Re: The Haymarket (SSD 6013) – Construction of a mixed use commercial office building & above ground public car park within the North West Plot, together with public domain improvements

Thank you for your letter about the proposed development referenced above. Sydney Water has reviewed the proposal and provides the following comments for your consideration.

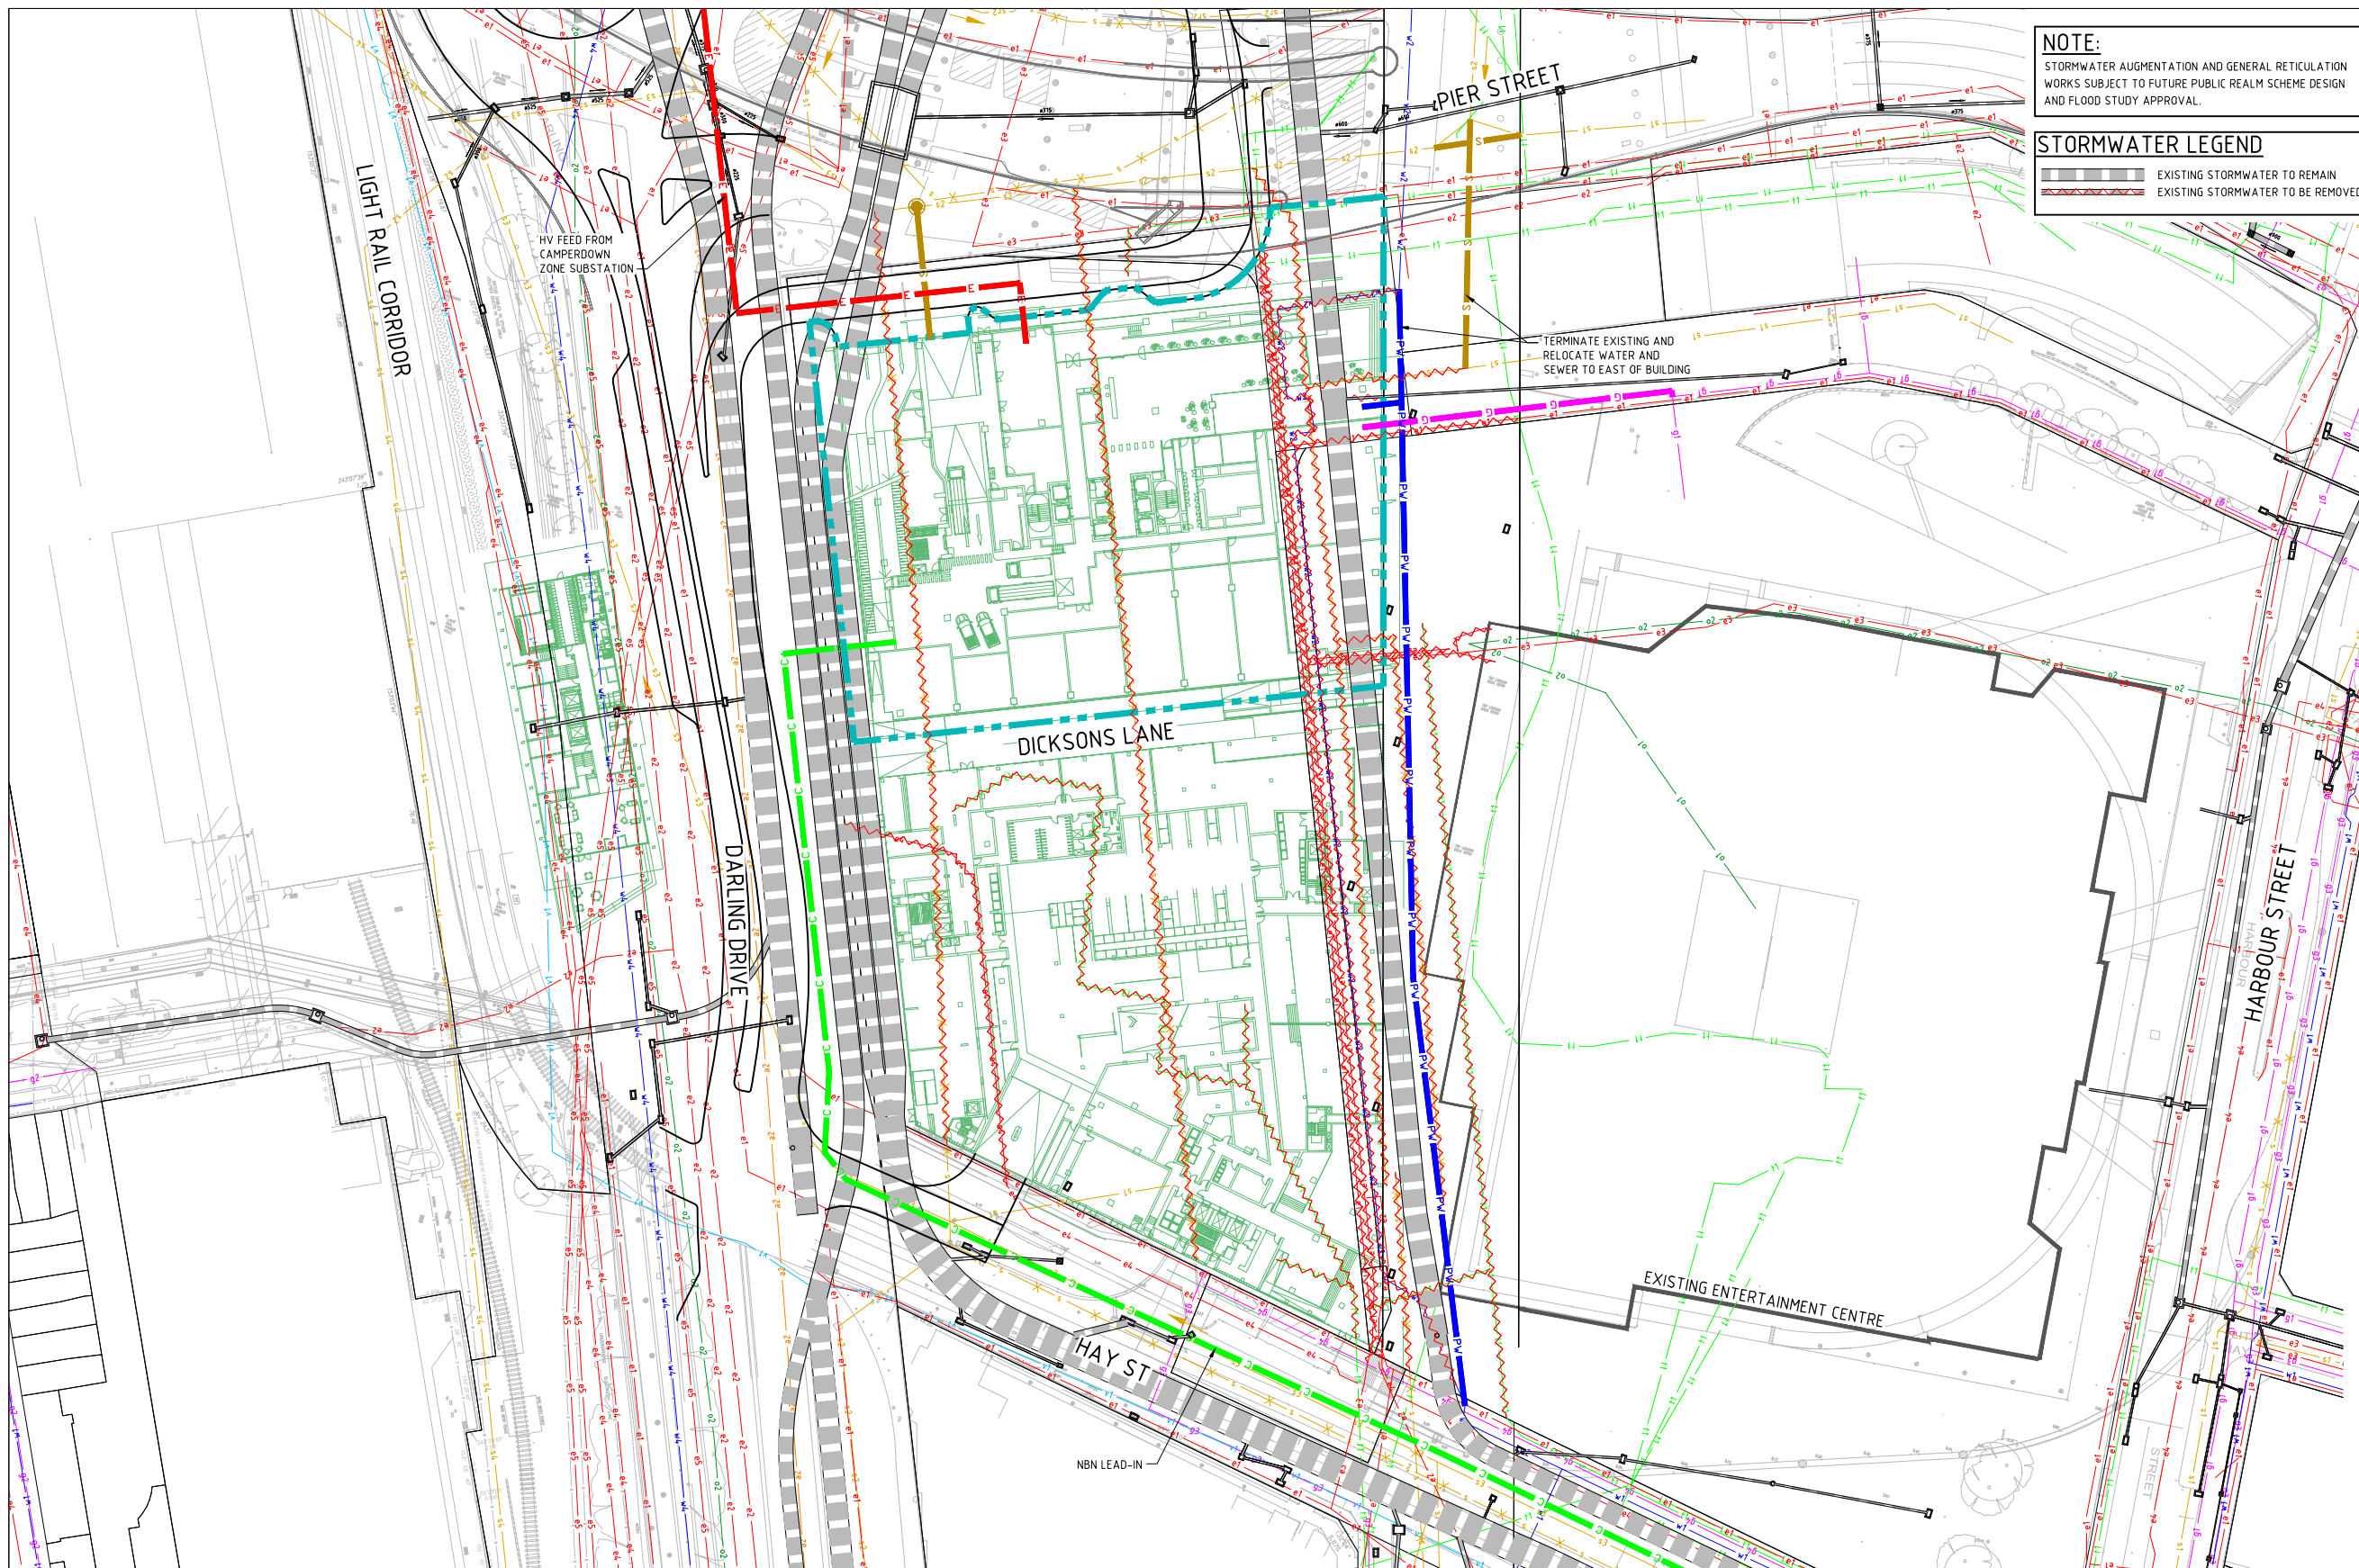
- The proposed lot and building footprints indicate a section of reticulation water main between Hay and Pier Streets along Lackey Street and an easement that will need to be relocated/adjusted.
- The existing trunk water supply system has sufficient capacity for the building.
- The 200mm water main on Lackey Street and the easement will need be adjusted to accommodate building NW1 and the alignment of the boulevard.
- A minimum 200mm water main covering the property frontage will be arranged for normal connections and will benefit from dual supply options to a superior supply.
- The overall local strategy will be referenced at the Section 73 stage.

- The existing trunk sewer system has sufficient capacity for the building.
- A reticulation connection will be extended from the nearest available sewer.
- A 300mm cast iron sewer may be adjusted or decommissioned, depending on the circumstances.
- The proposed lot and the building footprints indicate it is provided with a sewer connection under the National Code.
- The overall local servicing strategy will be referenced.
